From: [REDACTED]
To: [Gatwick Airport](#)
Subject: Submission from Sussex Ramblers - Interested Party Reference number: 20044094
Date: 02 June 2025 10:28:29

In response to Gatwick Airport Ltd's letter of 24 April 2025, The Ramblers maintains its objection to the proposal for a second runway at Gatwick airport.

Temporary NCR 21 Diversion

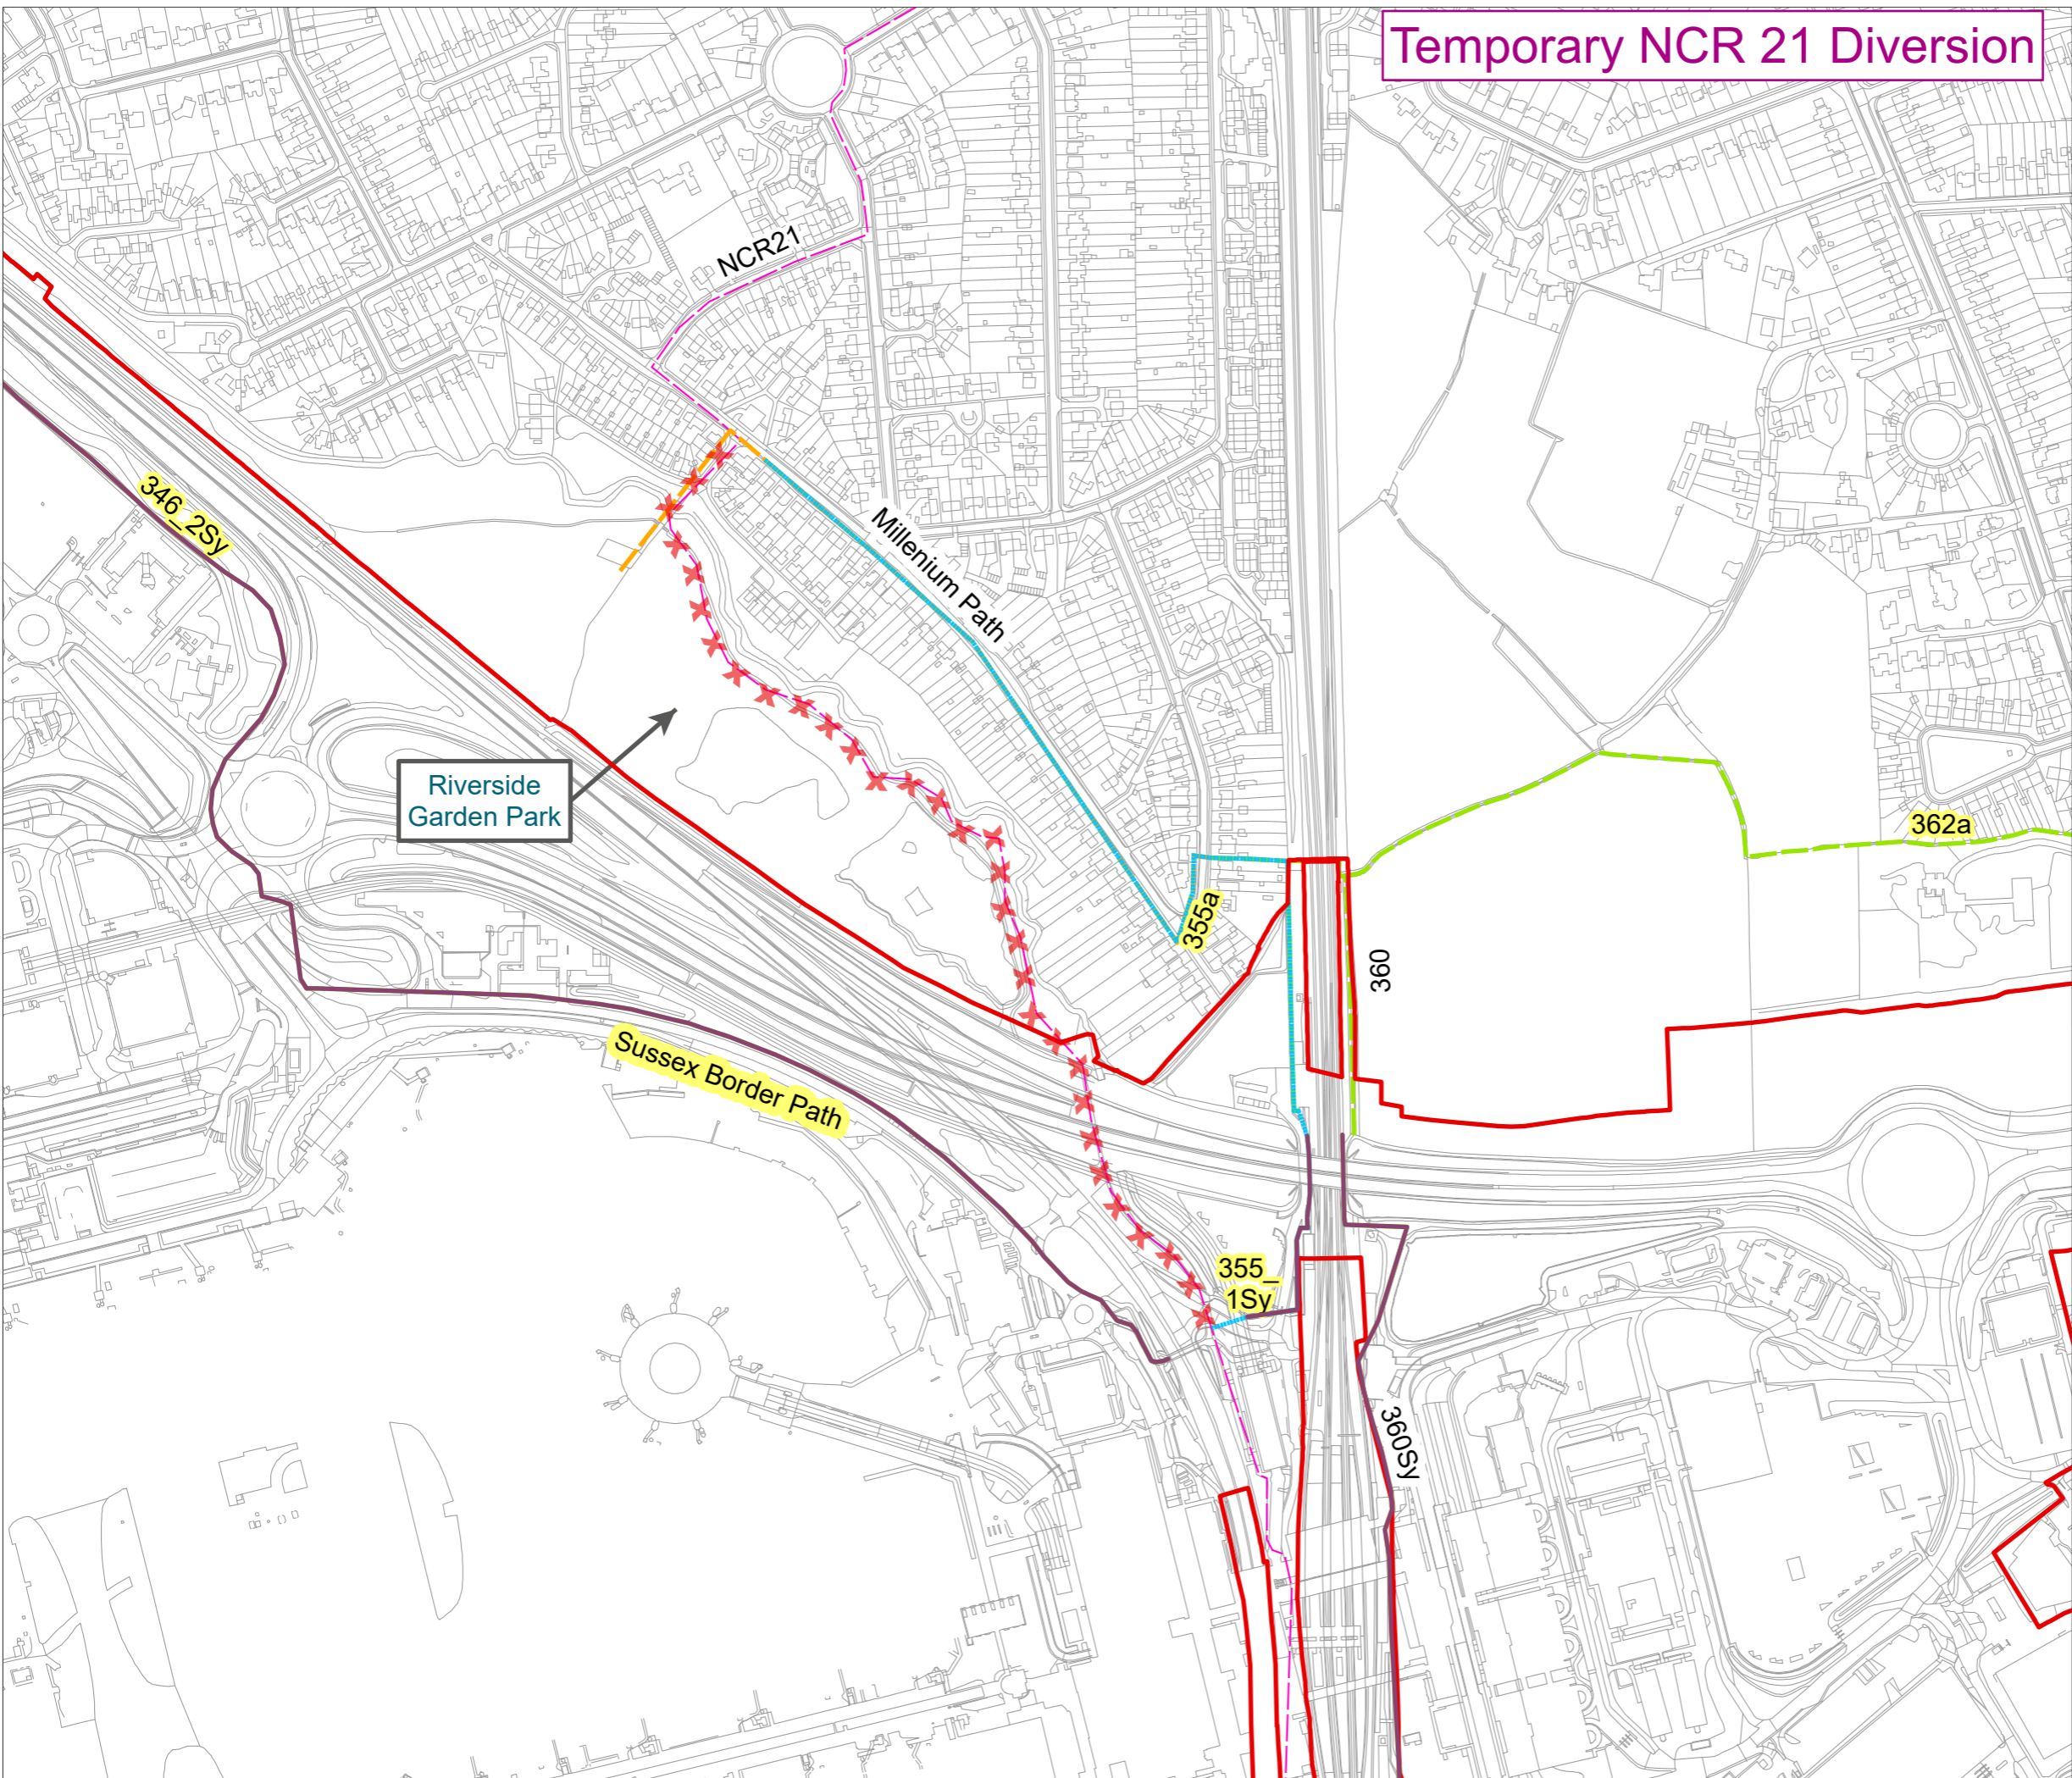
- Sharing it with National Cycle Route 21 means a loss of enjoyment and convenience for walkers, who must compete with cyclists.
- NCR 21 is itself to be temporarily diverted on to The Crescent, so more road walking again!
- And where NCR 21 rejoins its existing route, where's the continuation of the Sussex Border Path?

Temporary Sussex Border Path Diversion

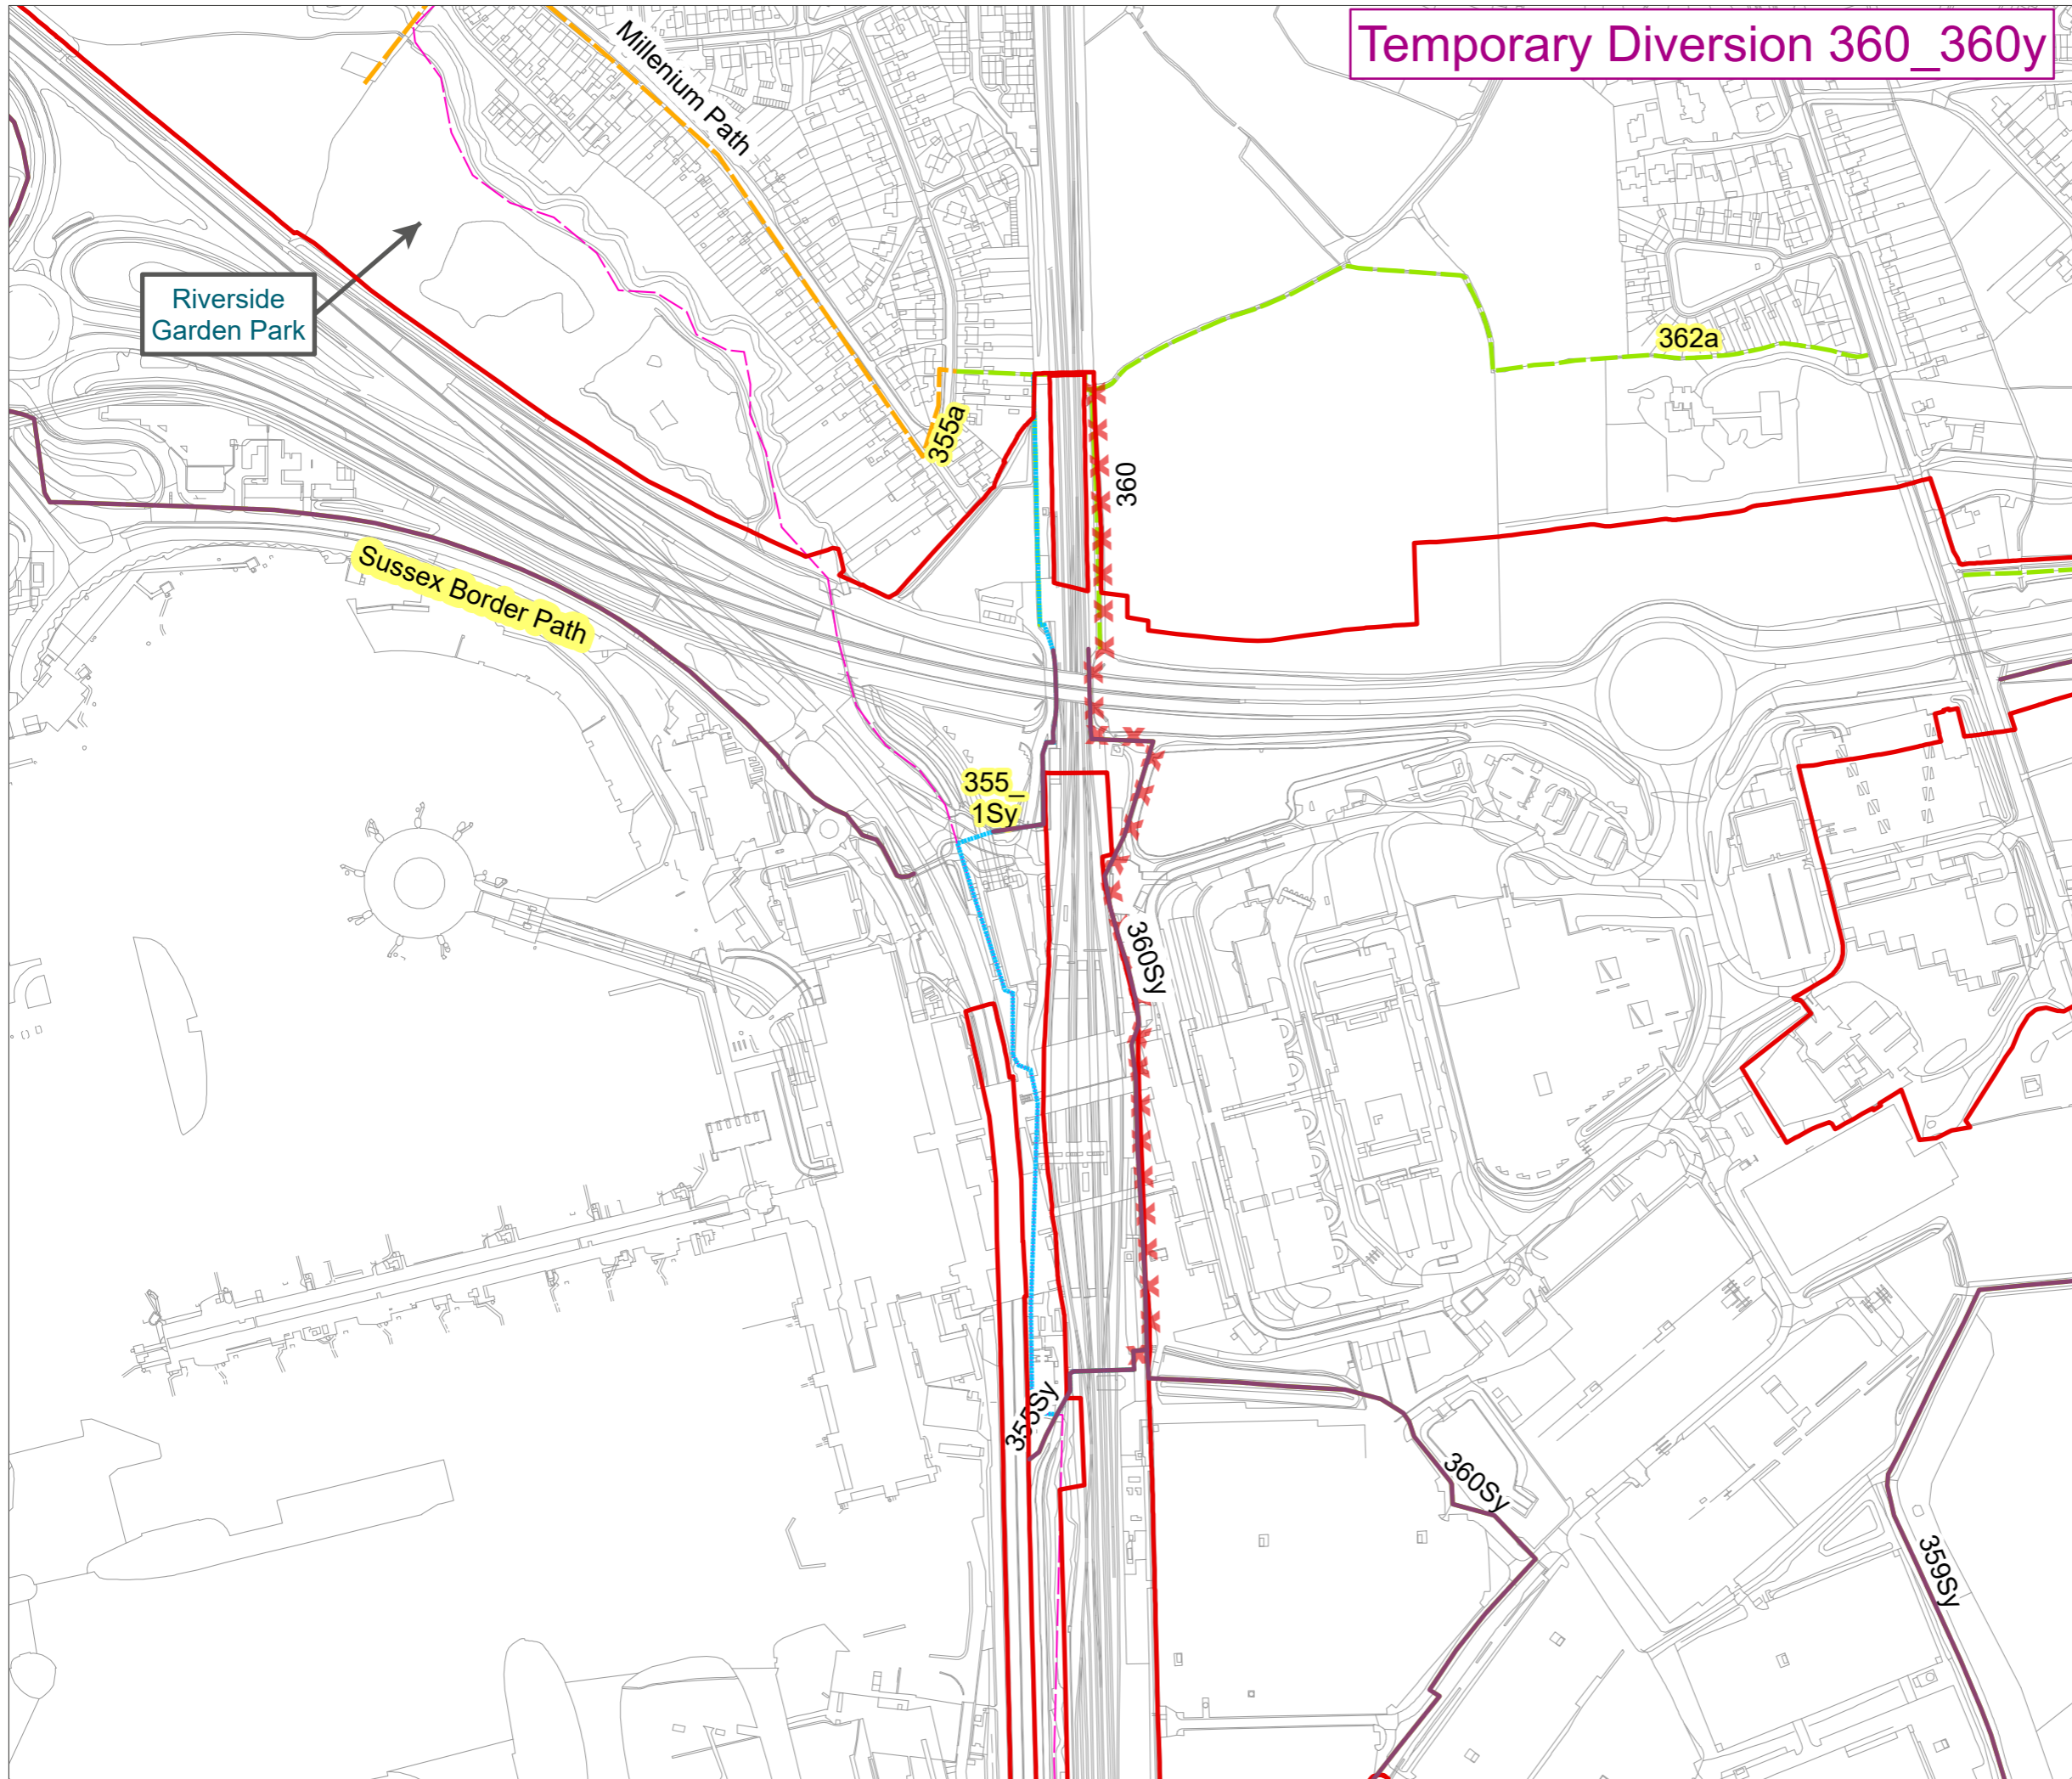
There are no references to the applicant's proposed changes to the public rights of way network, both temporary and permanent. We remain particularly concerned with their dismissive approach to the **Sussex Border Path** as this long distance trail was conceived by Sussex Ramblers over 40 years ago.

The temporary diversion of Footpaths 367 & 368 east of Balcombe Road is completely unacceptable. It is almost a mile longer, on a far less pleasant route, comprising:-

- Footpath 381, part of which is fenced-in and narrow.
- Haroldslea Drive, a narrow road with motor traffic, part with no footway.
- Nearly half a mile along Balcombe Road, a very busy B road.
